East Anglia One North (EA1N) and East Anglia Two (EA2) Offshore Wind Farms

Planning Inspectorate Reference: EA1N – EN010077, EA2 – EN010078

Deadline 7 – 4 March 2021

Comments of Suffolk County Council as Lead Local Flood Authority

**Plate 9.1 Flow chart summarising the Applicant's application of the SuDS hierarchy and strategy post-consent**

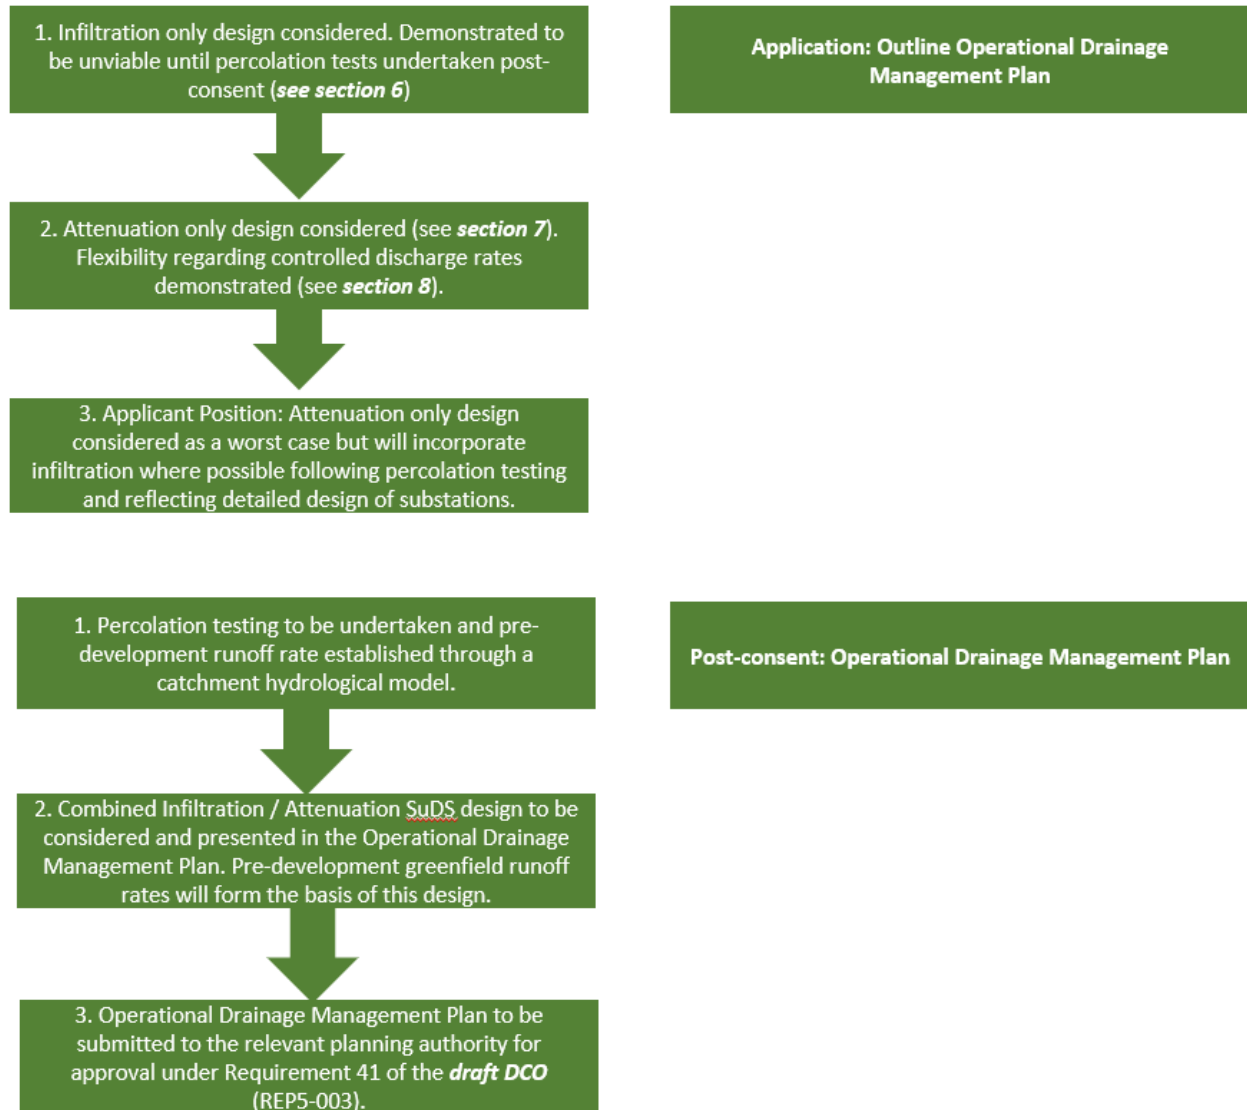
testing, detailed design of the onshore substations, National Grid infrastructure and the operational surface water drainage system itself.	
Plate 9.1	See submission	This diagram does not allow for an infiltration only design, contrary to national and local guidance and best practice, as per SCC LLFA response to paragraph 6, above.
References		Given the considerable discussion on the surface water disposal hierarchy it is noted that no reference is made here to the National Planning Policy Guidance, which sets out the surface water disposal hierarchy.
	SuDS Infiltration Design Calculations	Design top area is stated as 1m deep, freeboard top area is stated as 1.3m deep. However, Design storage depth is listed as 0.7m with design freeboard + 0.3m (1.0m deep). These two statements are contradictory, which has been used for the calculations? 1 in 100 + CC + 1 in 10 + CC water depths for each basin, based on calculations are; SPR substation = 0.858m NG substation = 0.99m This complies with national and local guidance and best practice. This does not match the water depths annotated on the drawing in Appendix 3, SCC assume these need to be corrected to mirror the calculations provided?

DRG No.	ED11892-C-SK10	REV	G
DRG SIZE	A3	SCALE	NTS
DATE	SEPT'20	APPROVED BY	SH
DRAWN BY	JN	CHECKED BY	CS

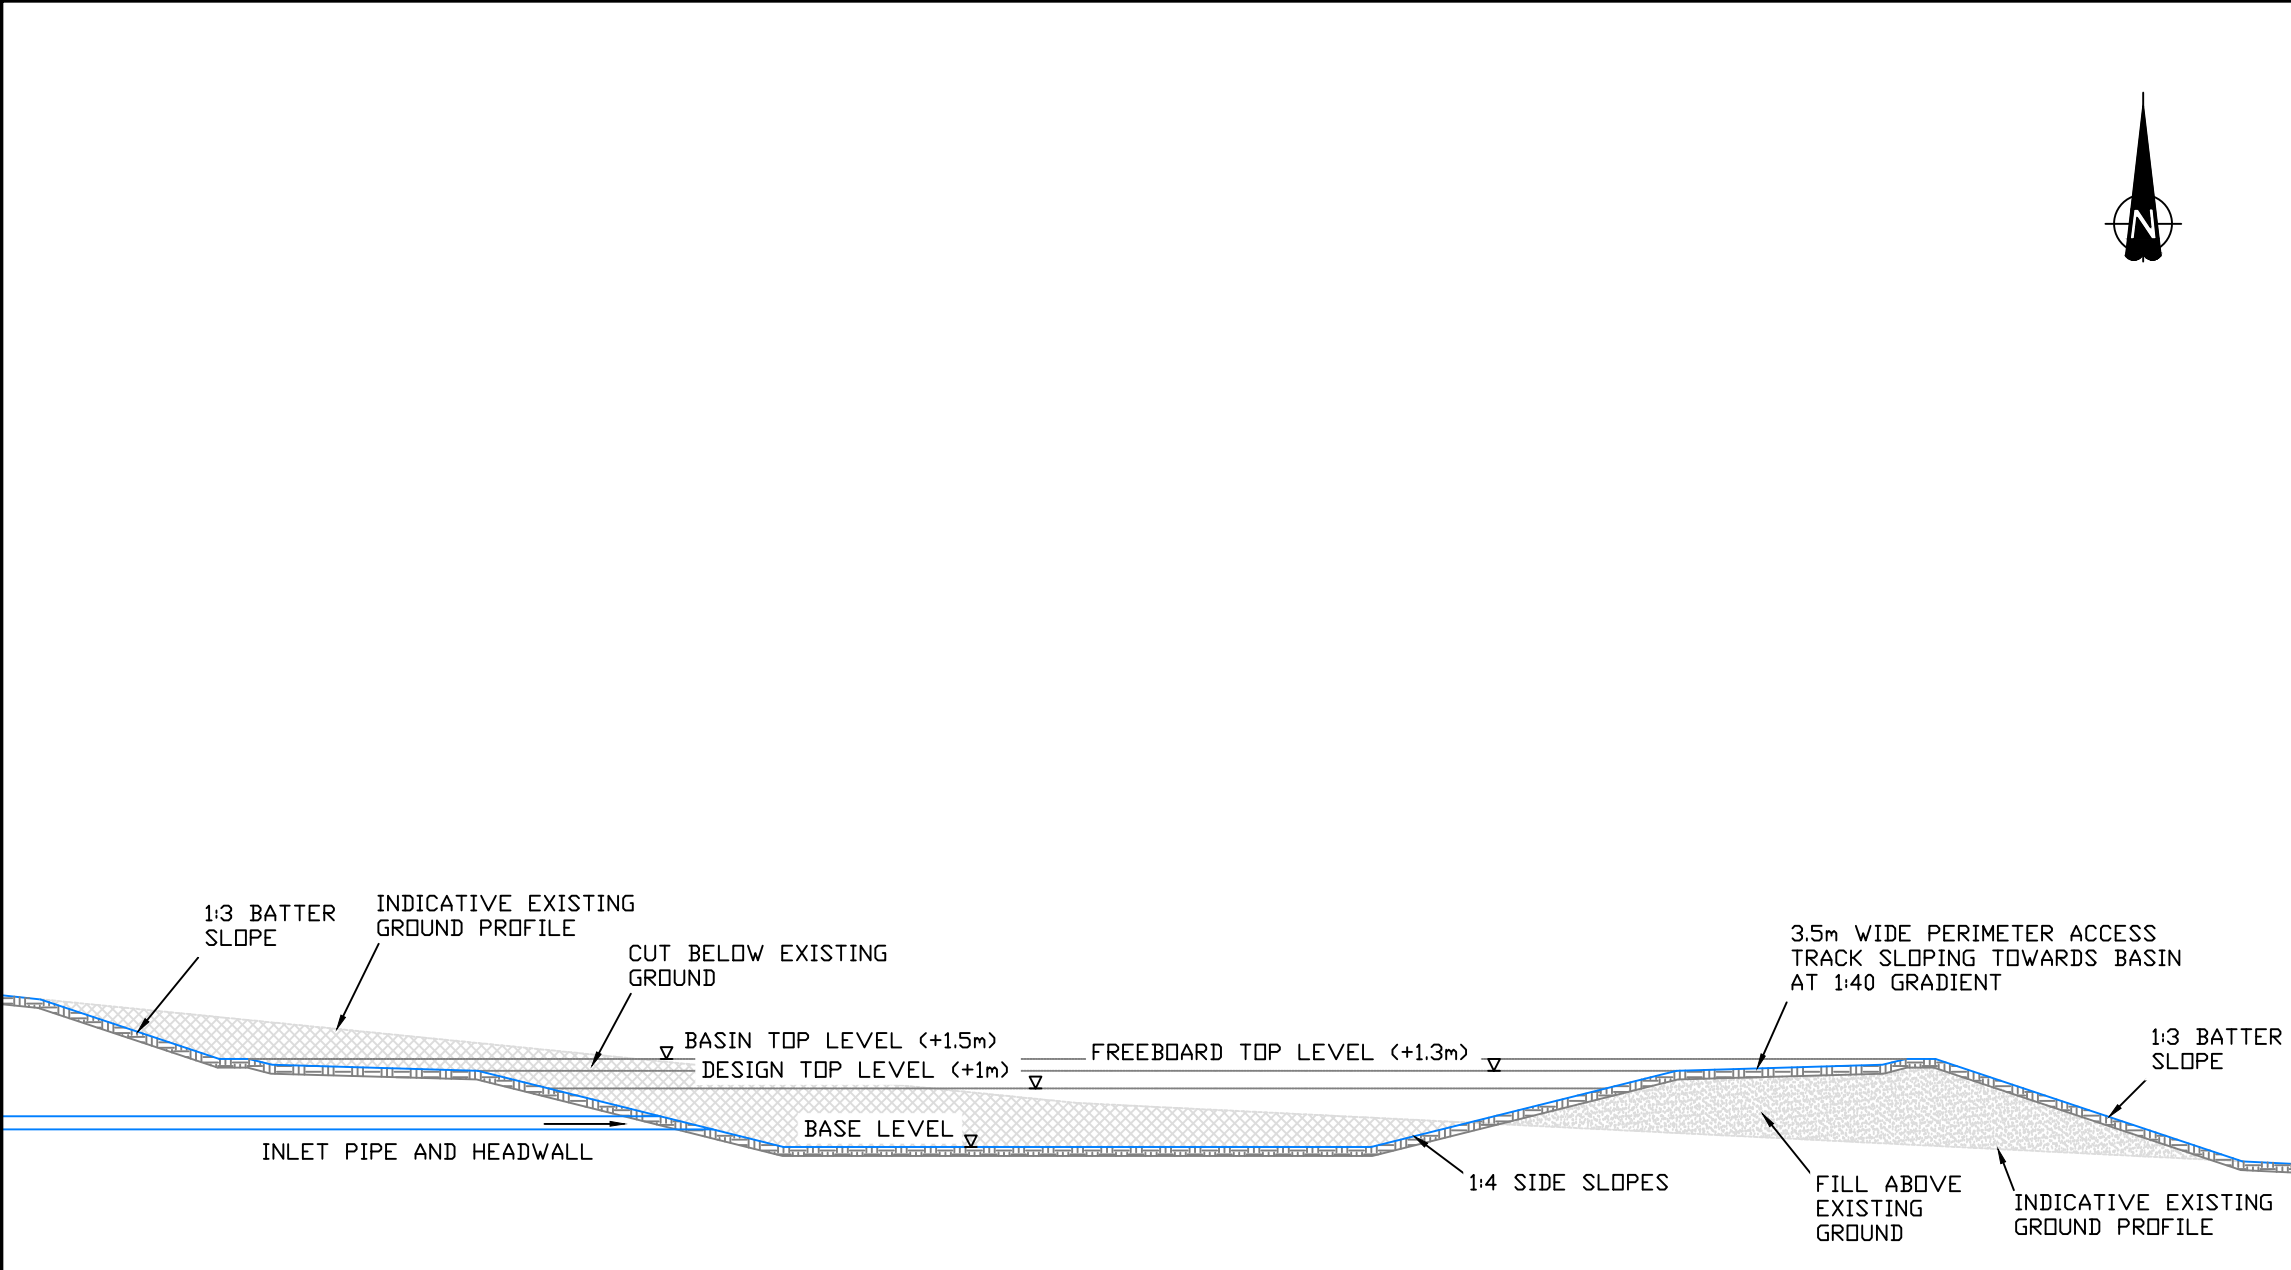
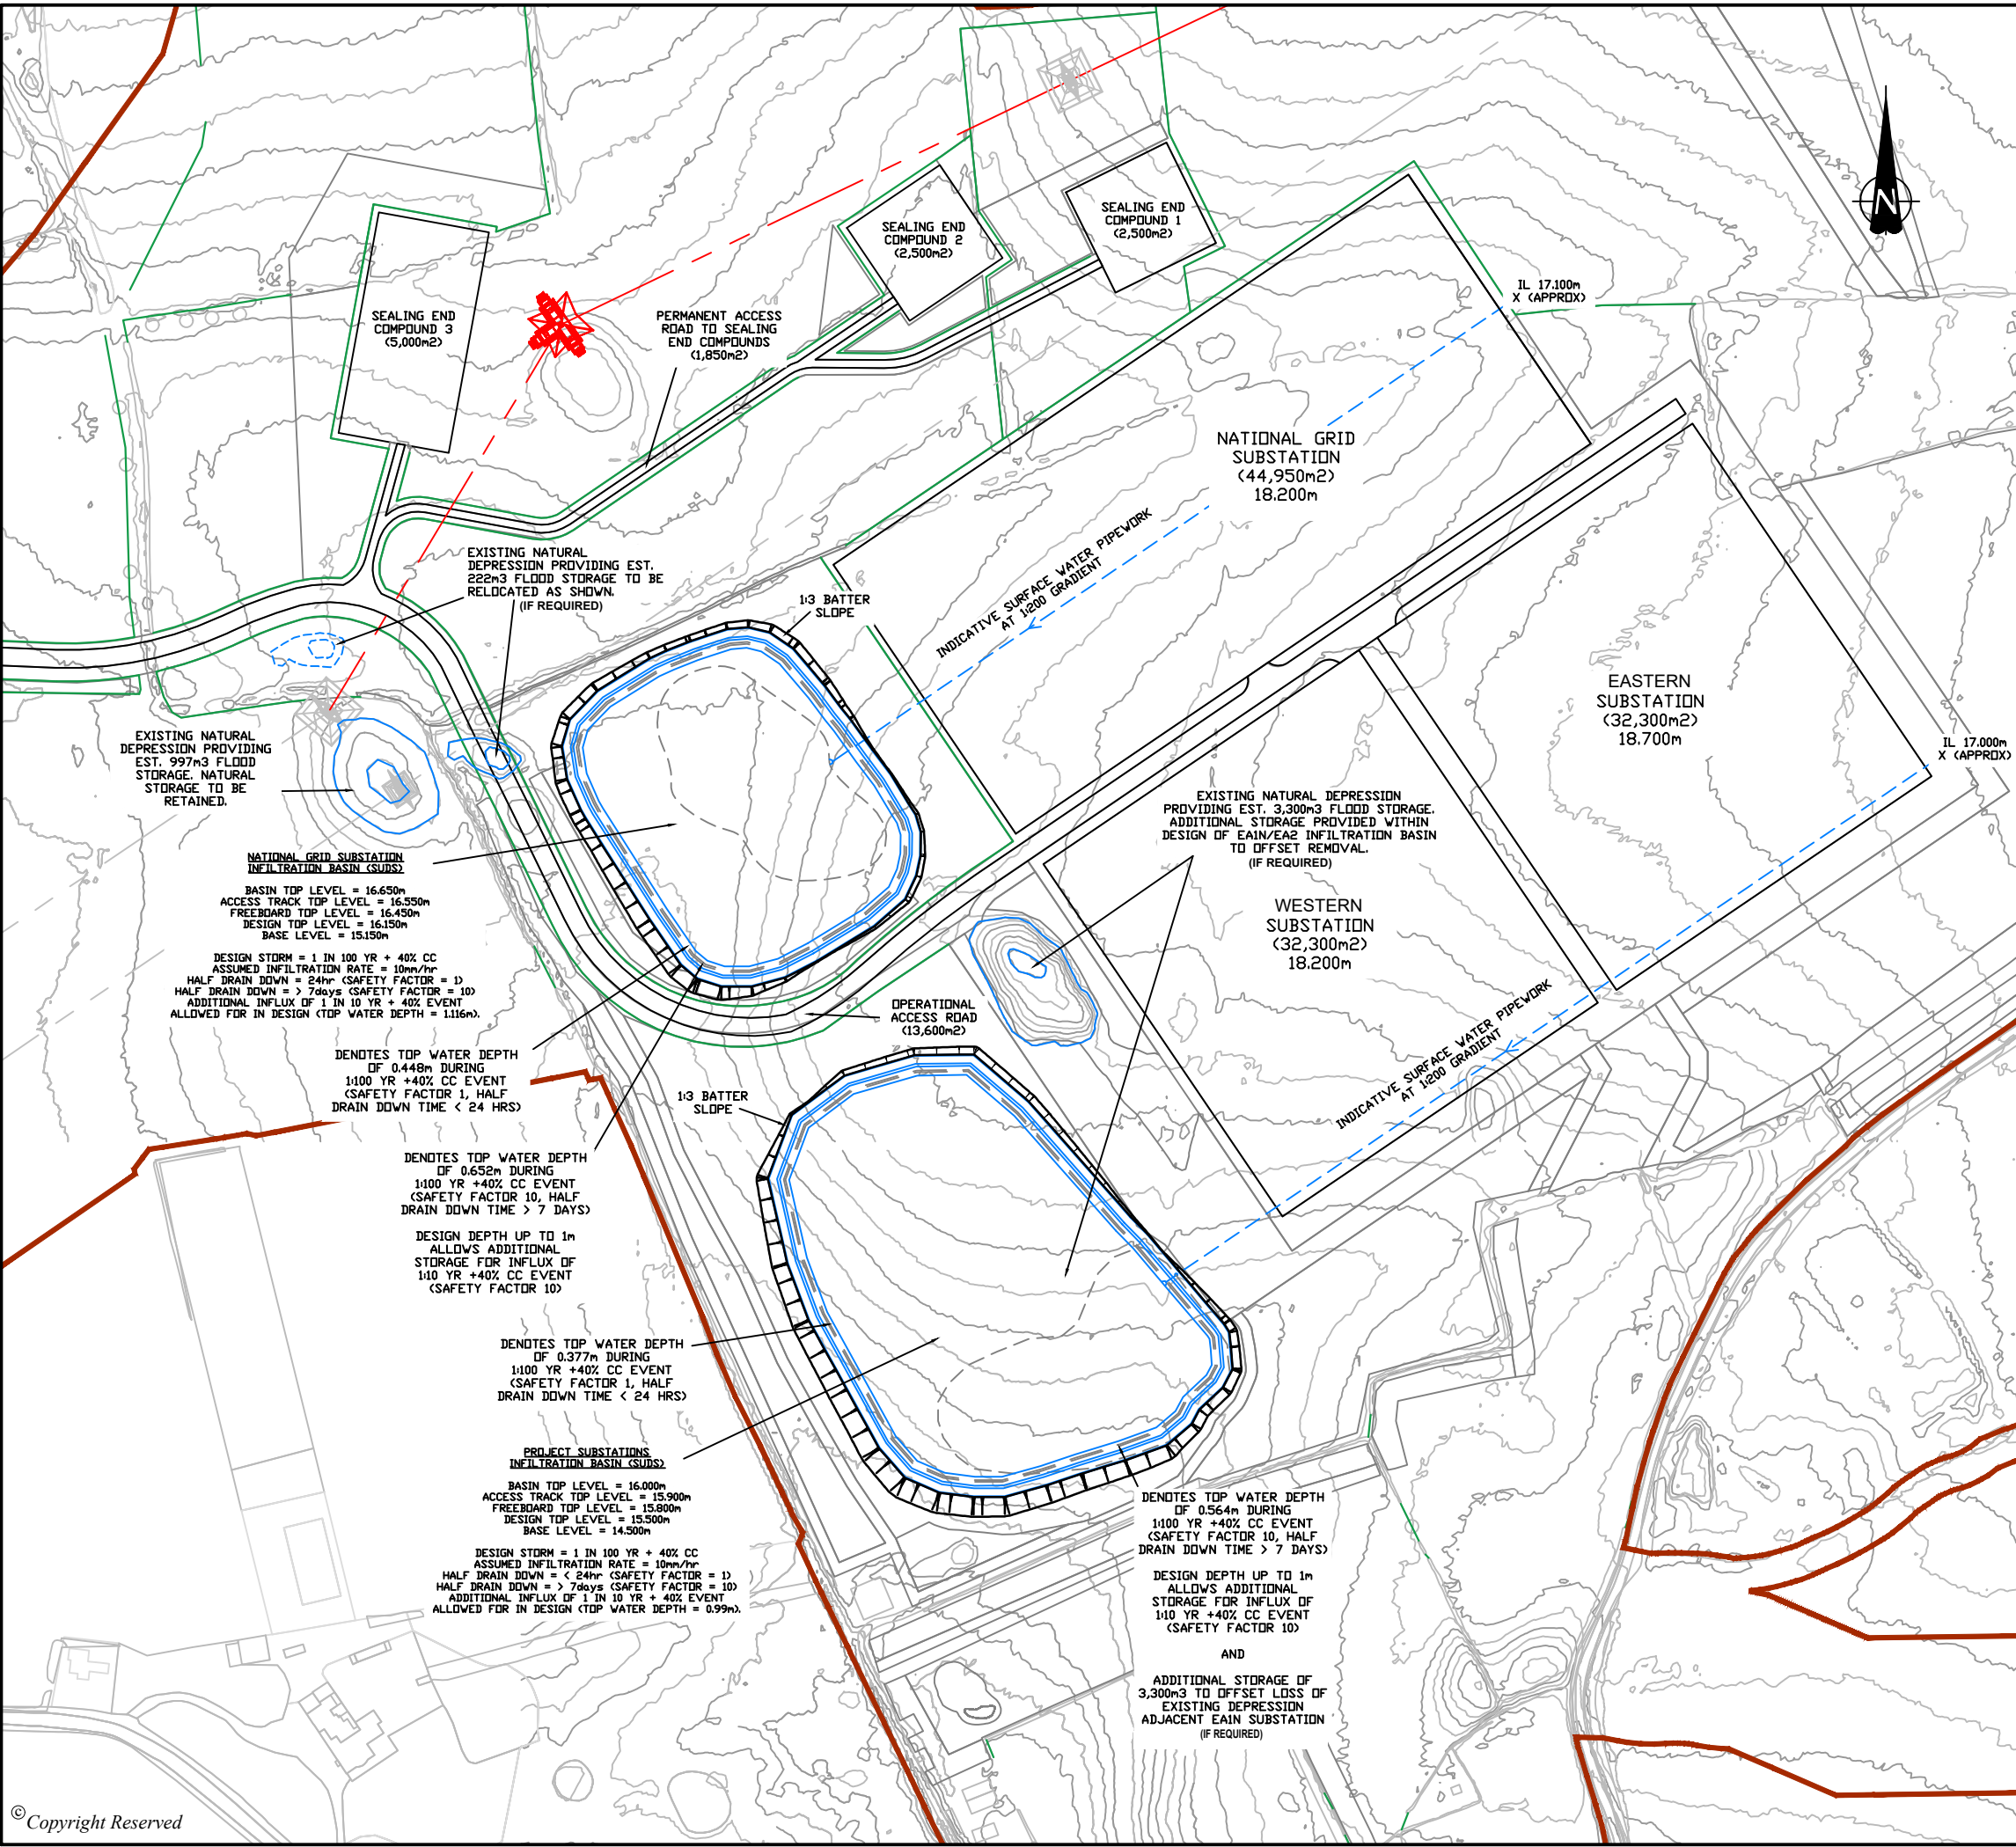
Appendix 3, Drawing No: ED11892-C-SK10-G	Existing natural depression providing est 222m ³ cannot be moved to proposed location. The proposed location is served by a different extent of the hydraulic catchment and would therefore not be a like for like replacement of the existing flood storage area.
	Appendix 4	Calculations meet national and local design guidance and best practice
